# Appeal Decision

**Appeal Ref: APP/R5510/W/23/3315732**

**4 Church Close, West Drayton, Hillingdon, UB7 7PY**

- The appeal is made under section 78 of the Town and Country Planning Act 1990 against a failure to give notice within the prescribed period of a decision on an application for planning permission.
- The appeal is made by Mr B Hafuzi (GBH Property Ltd) against the London Borough of Hillingdon.
- The application Ref. 27891/APP/2022/2859 was dated 13 September 2022.
- The application sought planning permission for the conversion of existing 6 people C4 HMO to a 7 people sui generis HMO.

#### PROPOSED LANDSCAPE, PARKING, CYCLE & REFUSE STORAGE PLAN (1:100)

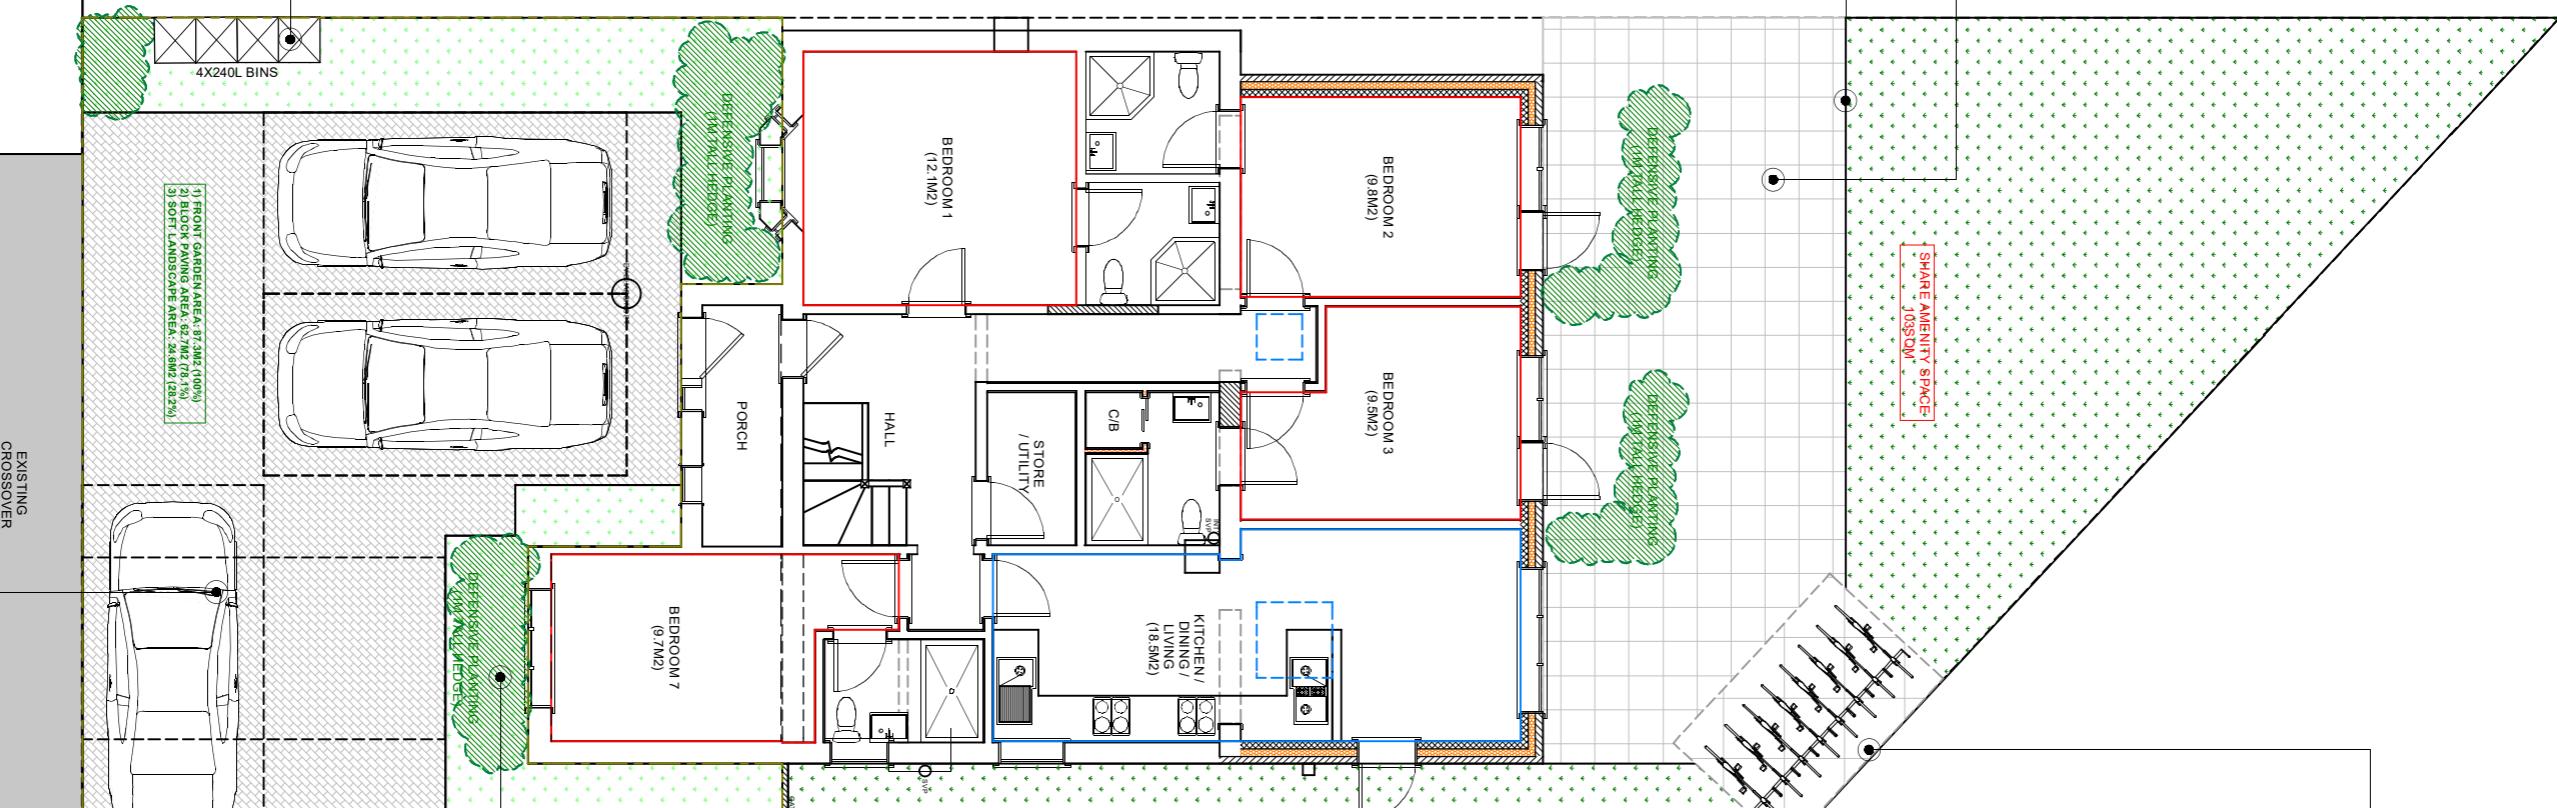
5. The frontage to the appeal site is already used as off-street parking to serve the existing HMO. Although the individual spaces are not marked out on site, the submitted plans indicate that there is room for up to 4 spaces. However, I note that the existing layout plan does not reflect that on site in that it omits some existing shrubs and a grassed area along the common boundary with 6 Church Close. The latter restricts the extent of the frontage available for parking, suggesting that the amount of space available to park 4 cars is tight. Even so, the proposed layout shows parking for up to 3 cars as well as the introduction of new landscaping margins and refuse storage (for up to 4 bins).

6. The Council contend that the proposed parking layout, in particular the space that is shown parallel to the road, would be difficult to access and exit. I am not convinced that that is the case, but even so, the Appellant indicates that this space could be turned 90° so that, as with the other 2 spaces, it fronts onto the road. That arrangement would be similar to existing and would, in my view, represent an acceptable revised layout that could be secured by condition. Whilst there could be the potential to accommodate 4 spaces, that would compromise the margins provided for new landscaping and the space available for refuse storage, improvements that would benefit both tenants and the wider streetscene. However, even with the provision of 3 parking spaces, the Council contend that the proposal would result in a shortfall of off-street parking that would be harmful to highway safety.

14. Within the above context, I am satisfied that the proposed layout could be revised to accommodate 3 spaces in a similar arrangement to existing and that this would provide sufficient pedestrian and vehicle visibility. However, other than anecdotal evidence, there is no substantive evidence which demonstrates that even the existing HMO gives rise to any significant issues in relation to on-street parking. Similarly, there evidence that the provision of 1 additional person (occupant) would result in any additional impact or lead to the demand for a further on-site parking or as to why available on-street parking could not meet any demand that may arise.

24. I have also added a condition that requires the submission and approval of a revised parking layout to reflect my earlier findings and in the interests of highway and pedestrian safety.

- 5) Notwithstanding condition 2) above and the details of the car parking layout shown on the submitted plans, no development shall take place until a revised car parking layout plan, showing the provision of three parallel car parking spaces fronting onto Church Close, has been submitted to and approved in writing by the Local Planning Authority. The development shall be carried out in accordance with the approved details.
